Ref: EN010163 - Response from NCC

Steeple Renewables Project

With regard to the recent request for comments relating to additional information dated the 25th August 2026, NCC have the following comments to make.

## FIGURE 6.9 – LANDSCAPE AND ECOLOGICAL MITIGATION STRATEGY (SHEET 1 OF 6)

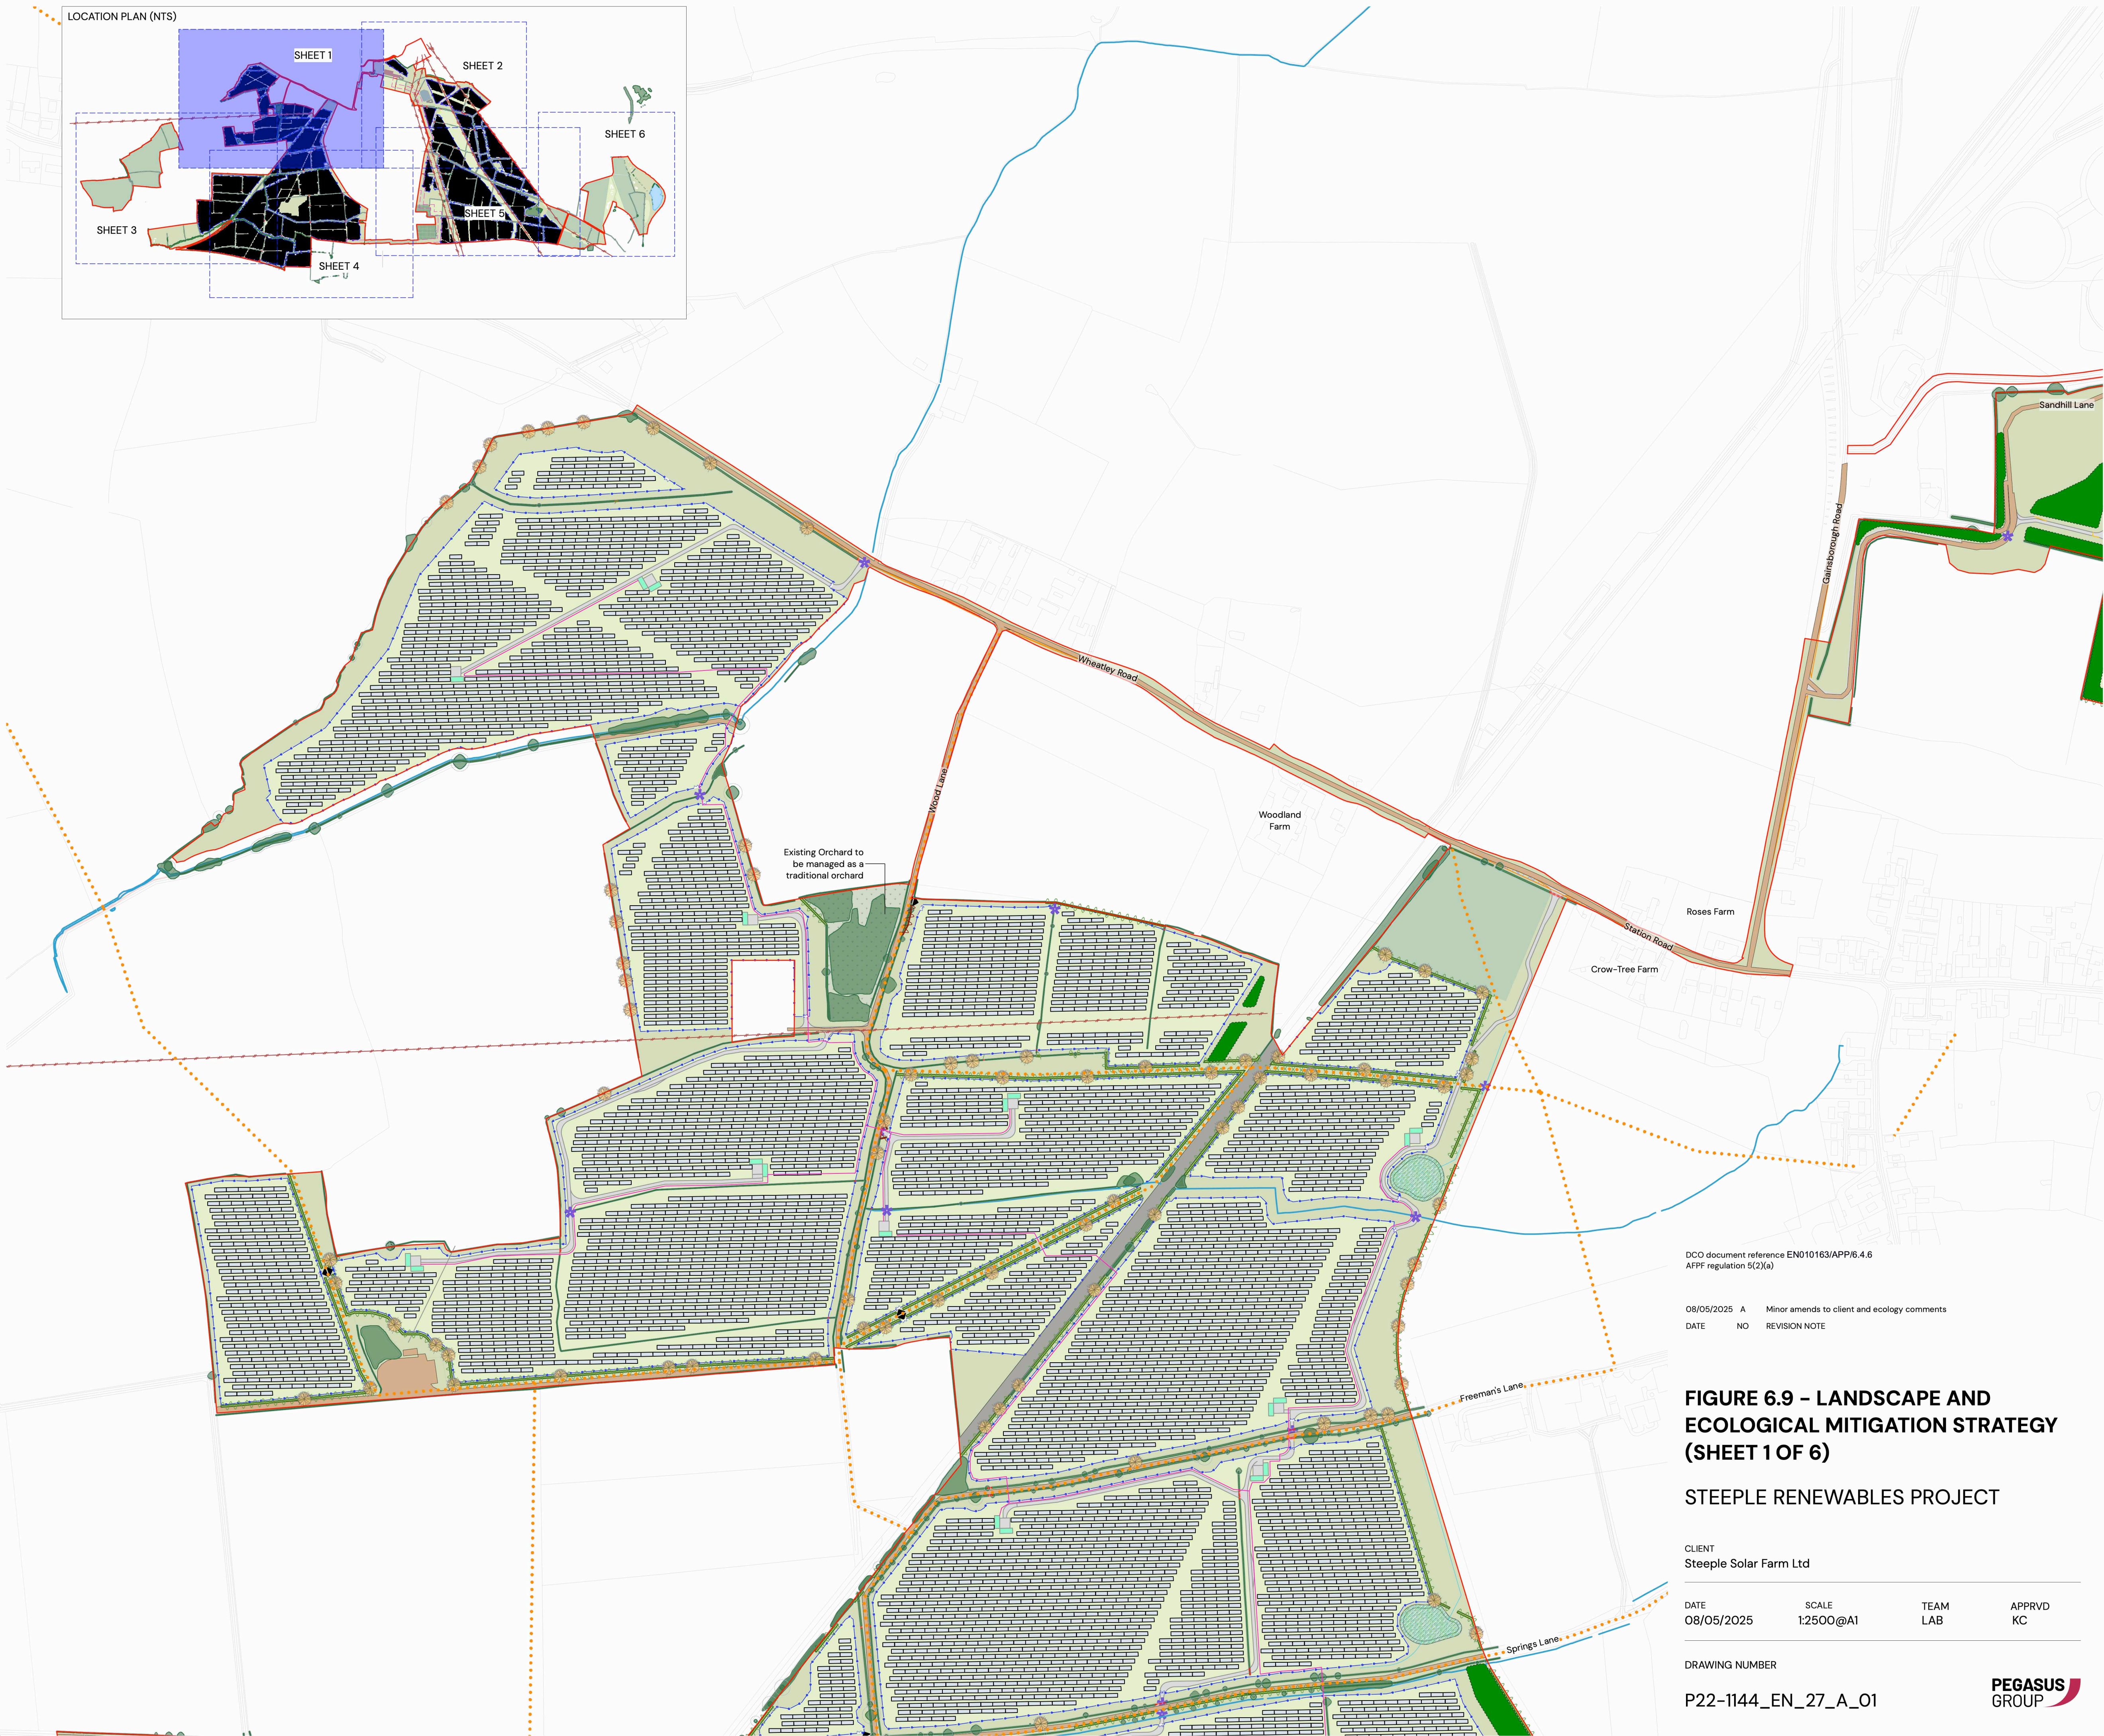
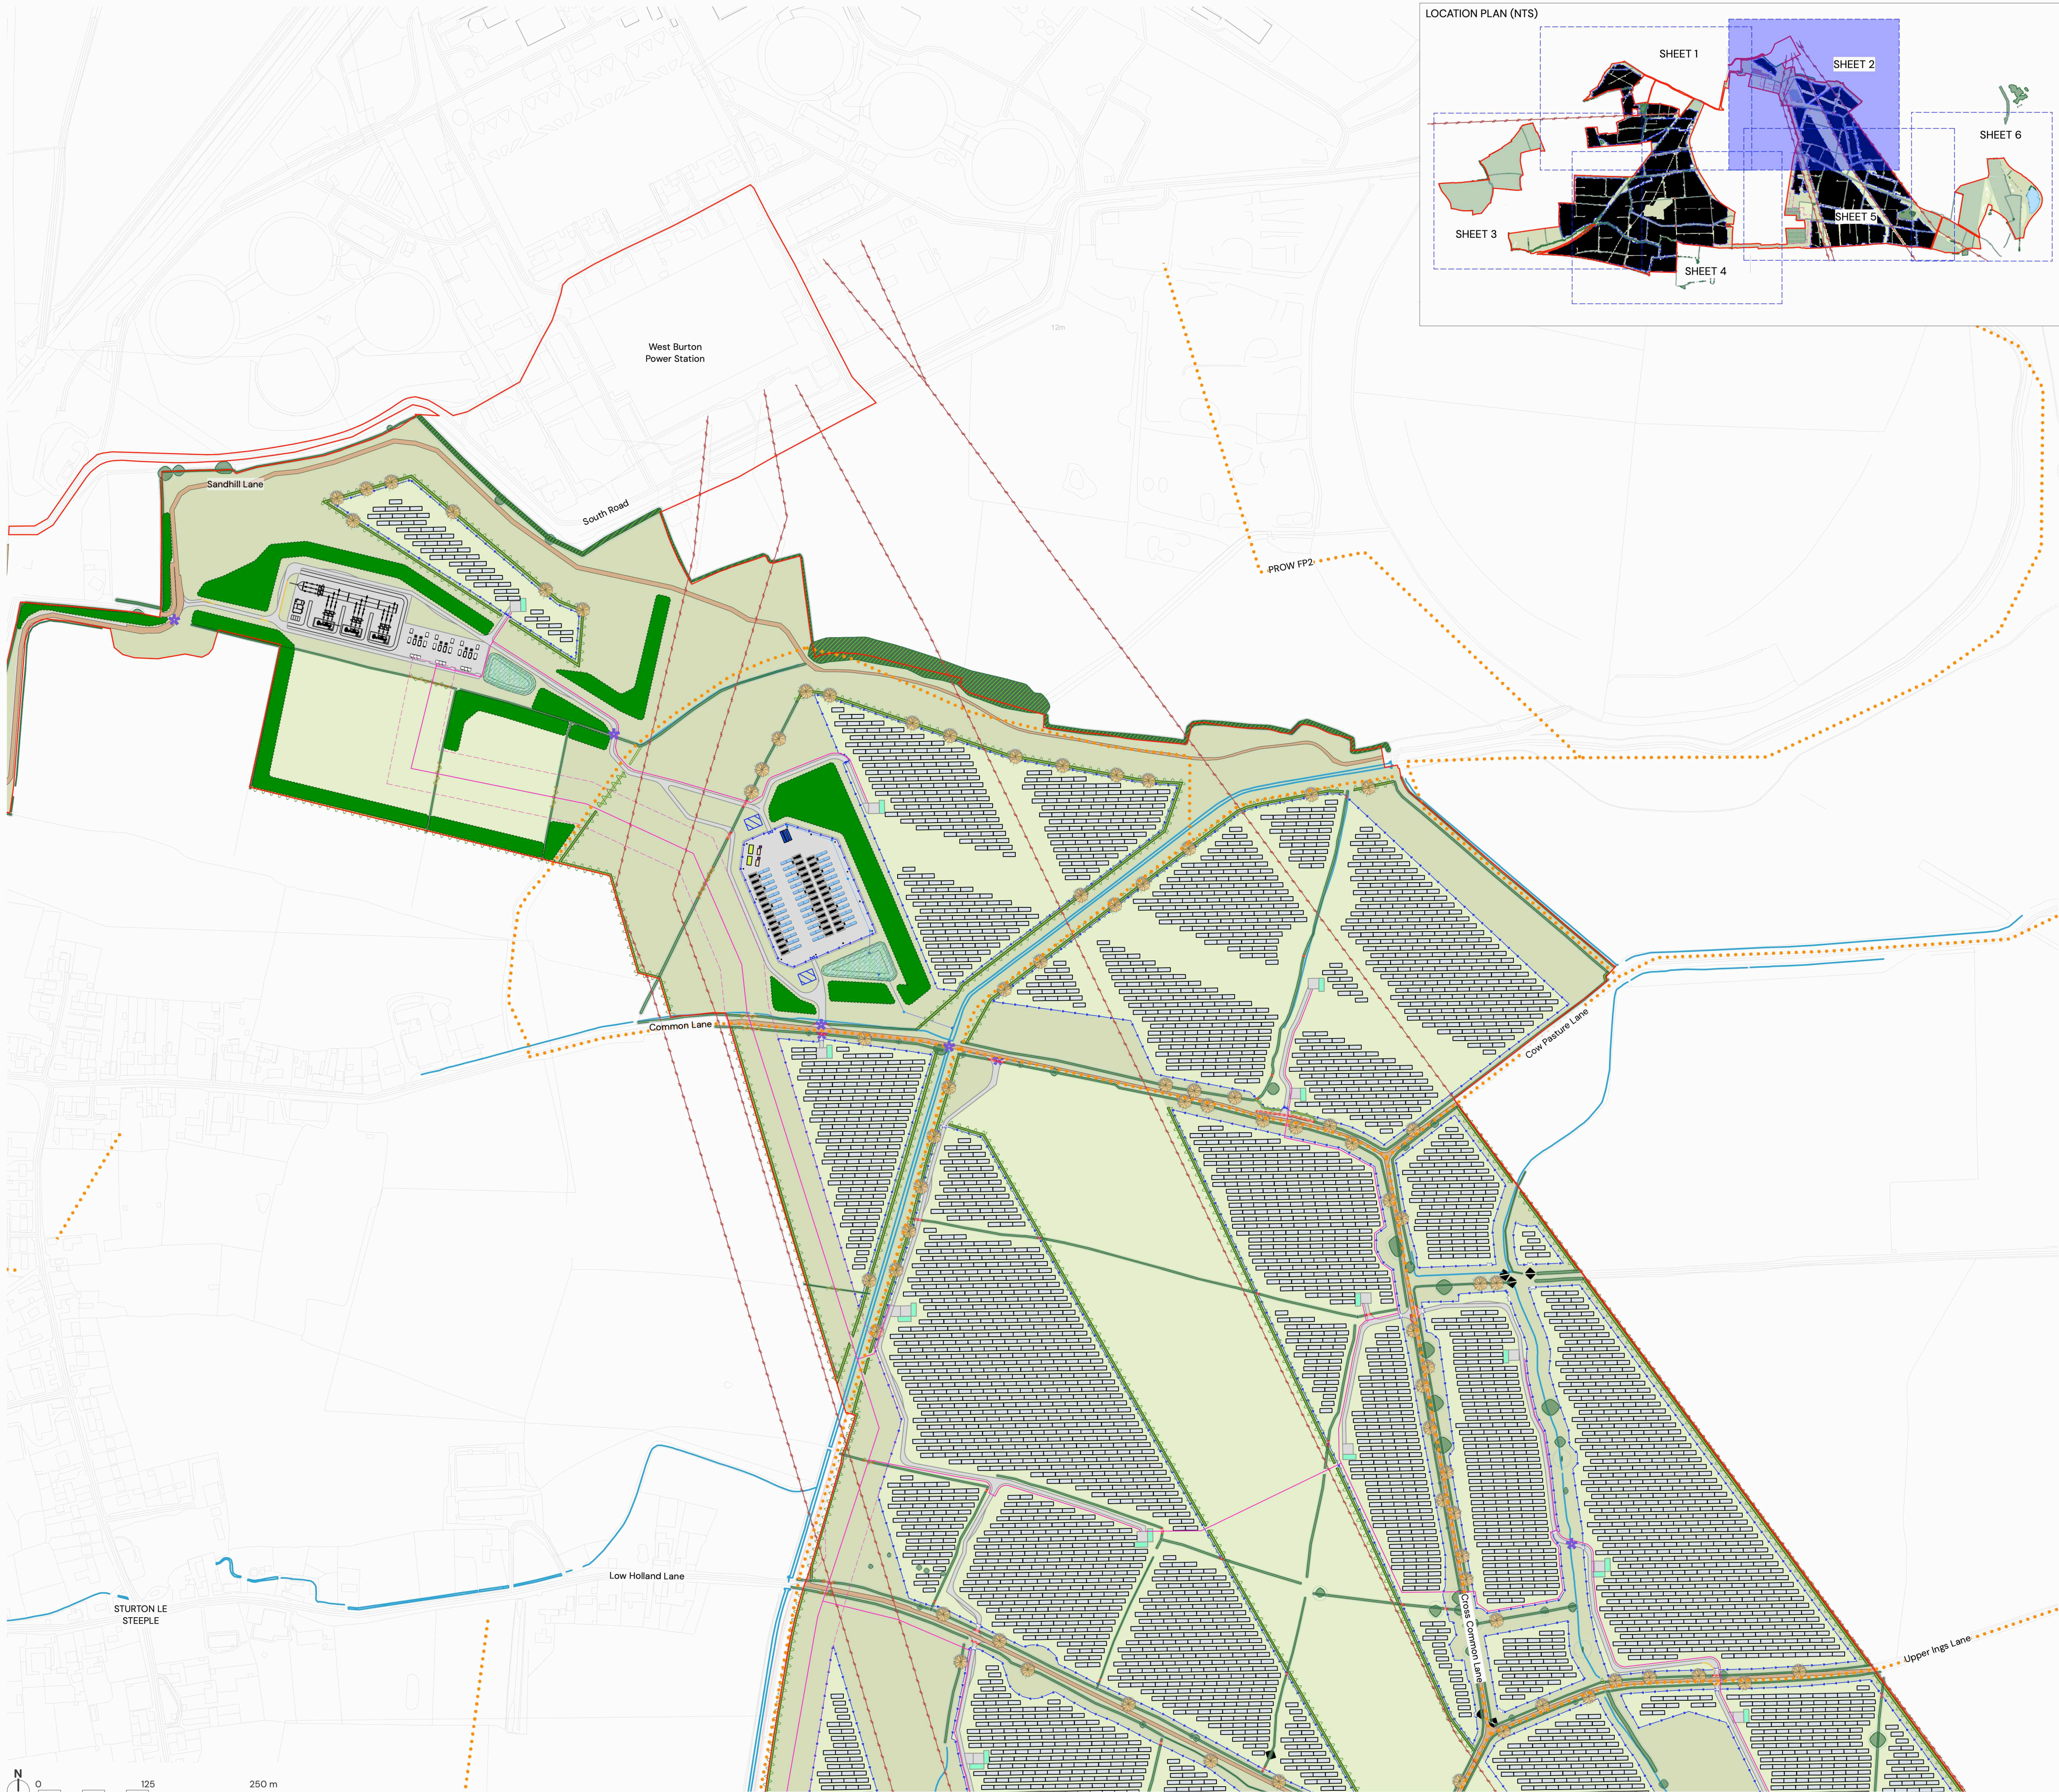
The additional native hedgerow proposed to the western side of the BESS is welcomed and is considered to provide an appropriate additional layer of landscape mitigation. Its location close to the BESS compound should assist in filtering and softening views of the perimeter infrastructure in combination with existing and previously proposed vegetation.

It is agreed that the additional planting is unlikely to result in a change to the significance conclusions reported within the ES. However, it would be more accurate to recognise that the planting is expected to provide a slight further reduction in the degree of visual effect as it establishes, notwithstanding that this would ultimately not alter the reported significance judgement.

The final LEMP should clearly identify the additional hedgerow and provide an appropriate planting specification including species composition, planting density, establishment and management proposals and intended management height and width. I note that existing and enhanced hedgerows are proposed to be maintained at approximately 2.5m in height and 1.5m in width. It should be confirmed whether these dimensions would also apply to newly created hedgerows once established.

The final arrangement should allow sufficient separation between the proposed hedgerow, Security fencing and BESS infrastructure to allow the planting to establish and be maintained effectively. NFCC guidance states that combustible vegetation should be at least 3m from BESS infrastructure; however, engagement with the local fire safety officer should be consulted to confirm that the proposed arrangement and offsets are acceptable from a fire safety perspective.

From a landscape perspective, sufficient space should also be provided for long term maintenance access, with a minimum 2m maintenance strip recommended. The mature extent of the hedgerow should also be maintained at least 3m from the security fencing to reduce the potential for established vegetation to provide a climbing aid and compromise site security. The Applicant could also consider incorporating suitable thorny native species within the final hedgerow mix to provide an additional degree of natural deterrence.
